**PROPOSED MODIFICATIONS TO CONCEPT APPROVAL FOR DAN LAND - 290 & 302 MINMI ROAD FLETCHER (MP 06\_0031 MOD 2)**

The submission dated 25 August, 2015 prepared City Plan Services (CPS) and accompanying plan (MP-001) submitted in support of the request have been reviewed by Council officers and the following comments are offered for your consideration:

Figure 4: Proposed modification (Source: Proponent)

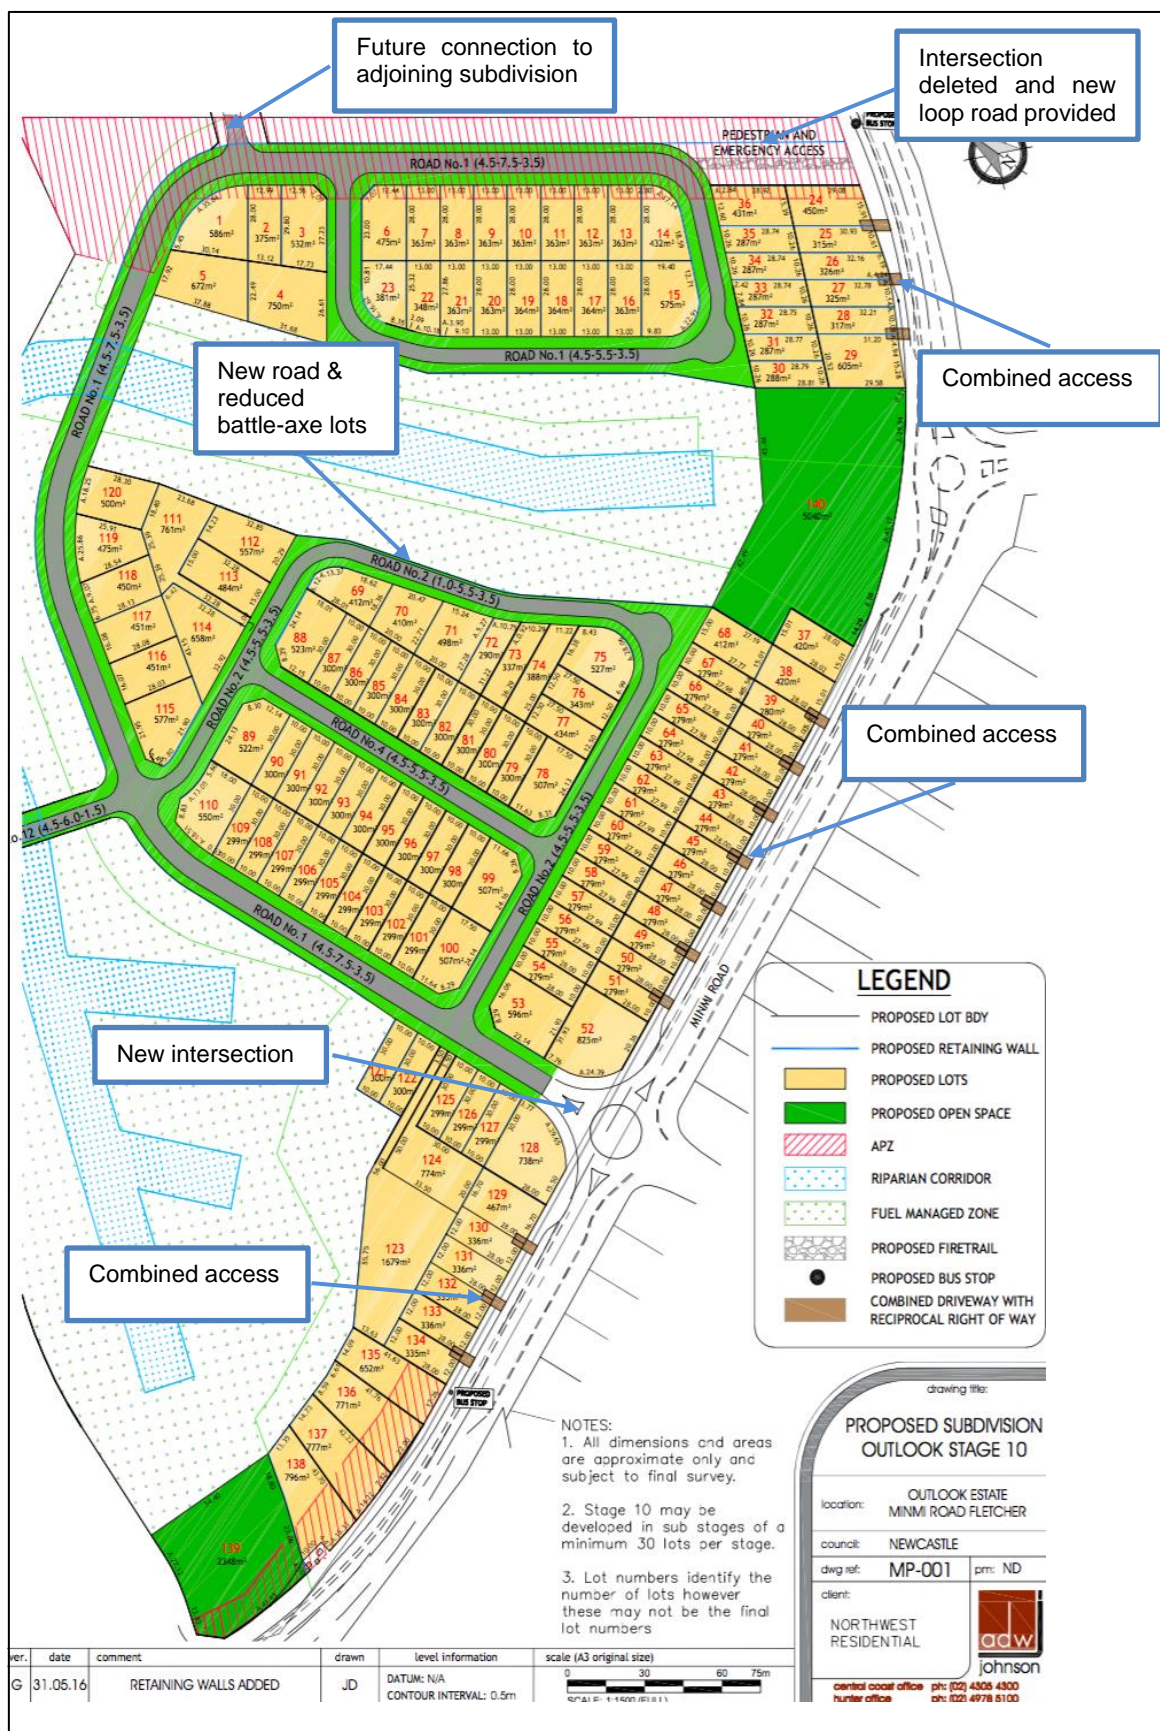
The total number of residential lots that would result from the approved Stages 1 to 9 (298 lots) and the proposed Stage 10 modification (137 lots) would result in a total residential yield of 435 lots. This total exceeds the current Concept Plan approval and Project Approval by a total of 35 lots and 98 residential lots, respectively. These exceedances have not been acknowledged, justified or discussed in the CPS submission.

On the approved 'Proposed Lot Layout' plan 'Town Houses' lots (having an approximate area of 250m<sup>2</sup>) were only proposed for a small enclave immediately opposite the commercially zoned land on the southern side of Minmi Road now occupied by an Aldi supermarket development. Clearly, the number of 'Town House' allotments, now proposed will dominate the Stage 10 area with 70 lots (51 % of the total Stage 10 yield) being proposed at 300m<sup>2</sup> or less in area.

The CPS submission fails to provide sufficient justification or discussion around the potential impacts of the significant increase in the number of lots having a site area of less than 300m<sup>2</sup>. It is recommended the proponent be required to address the above matter.

It is also recommended the Proponent be required to submit a plan which overlays the proposed subdivision layout onto the relevant zoning map of the NLEP, 2012. It being noted lot 19 appears to be in the E2 Environmental Conservation zone.

The CPS submission and proposed amended Stage 10 layout fails to consider this requirement as no appropriate provision has been made in the amended Stage 10 road and lot layout for this road and pedestrian connection.

It is recommended that the design of the proposed Stage 10 layout be further amended to incorporate this essential road and pedestrian connection between these estates.

The approved modified Concept Plan does not provide individual driveway access from Minmi Rd to land comprising Stage 10, with all vehicular access being contained to/from the internal road network. Under the proposed modification 34 separate driveways would be required and these driveways, based on the proposed lot frontages, would be spaced around every 10m (maximum).

No assessment has been made in the CPS submission on the suitability of Minmi Rd to cater for increased turning into and reversing from these proposed allotments and the increased potential for vehicles to be standing in and blocking the sole westbound travel lane while waiting to turn with the potential for an increase in the number of 'nose-to-tail' collisions.

It is noted that the existing Statement of Commitment No A.3.1 requires the proponent to providing road infrastructure to certain minimum design requirements based on the intended road hierarchy. The widths of the roads have not been dimensioned on the submitted plan, however, by digital scaling, it has been determined that the road carriageway widths shown are 5.5m and 7.5m wide. Council no longer supports 5.5m carriageway widths due to a history of complaints of parked vehicles causing obstructions to traffic.

Having regard to the future link to Sanctuary residential estate to the east (i.e. DA 97/0555), the majority of Road No. 1 has the potential to be a bus route and therefore is required to have a minimum carriageway width of 9.5m. Roads No. 2, 3 and 4 and the remainder of Road No. 1 are required to have a carriageway width of 7.5m.

As discussed in C2 above, the submitted plan indicates a significant number of lots having around a 10m wide frontage. It is considered these narrow frontages, combined with future driveways, are likely to impede vehicles being parked at the kerb in front of these lots without encroaching over driveways or causing an obstruction to vehicles traversing the street.

It is a matter of concern that the introduction of at least 34 new driveways (see C2 above), on average 10m apart, along the Minmi Rd frontage of Stage 10 will have a significant adverse impact on pedestrian and cyclist safety when compared to the current approval which allowed an unimpeded pathway.

- (i) Lots 15 and 110 have not been provided frontage to a public road.
- (ii) Lots 10, 11 33, 34, 131 and 132 rely on poorly sited access from road areas restricted by the existing and proposed roundabouts resulting in inappropriate and dangerous vehicle manoeuvring.
- (iii) Lots 128, 129, 130, 110 (assuming it is intended to share access with Lot 111) and 111 rely on undesirably long and curved driveways across an excessively wide footway area. Reversing manoeuvres along lengthy and curved driveways is not supported.
- (iv) Access to Lots 69 and 70 cannot be reasonably constructed from the squared ends of a 'hammerhead' turning area.
- (v) Council's DCP2012 does not permit a shared battle-axe handle to support more than two lots. Lots 50, 51, 52 and 53 will need to be consolidated and

developed as a single development site or the access driveway will need to be within Community or Neighbourhood Association property under a Community Title subdivision.

(vi) Lots 54 and 71 require splayed boundaries to ensure the footway width is maintained.

(vii) Lots 138 and 139 correspond with land identified as parkland and playground on the approved Vegetation Management Plan and Landscape Master Plan. In accordance with the current Concept Plan approval, these parklands and playgrounds are to be owned and managed by the Community or Neighbourhood Associations under the Community Title subdivision.
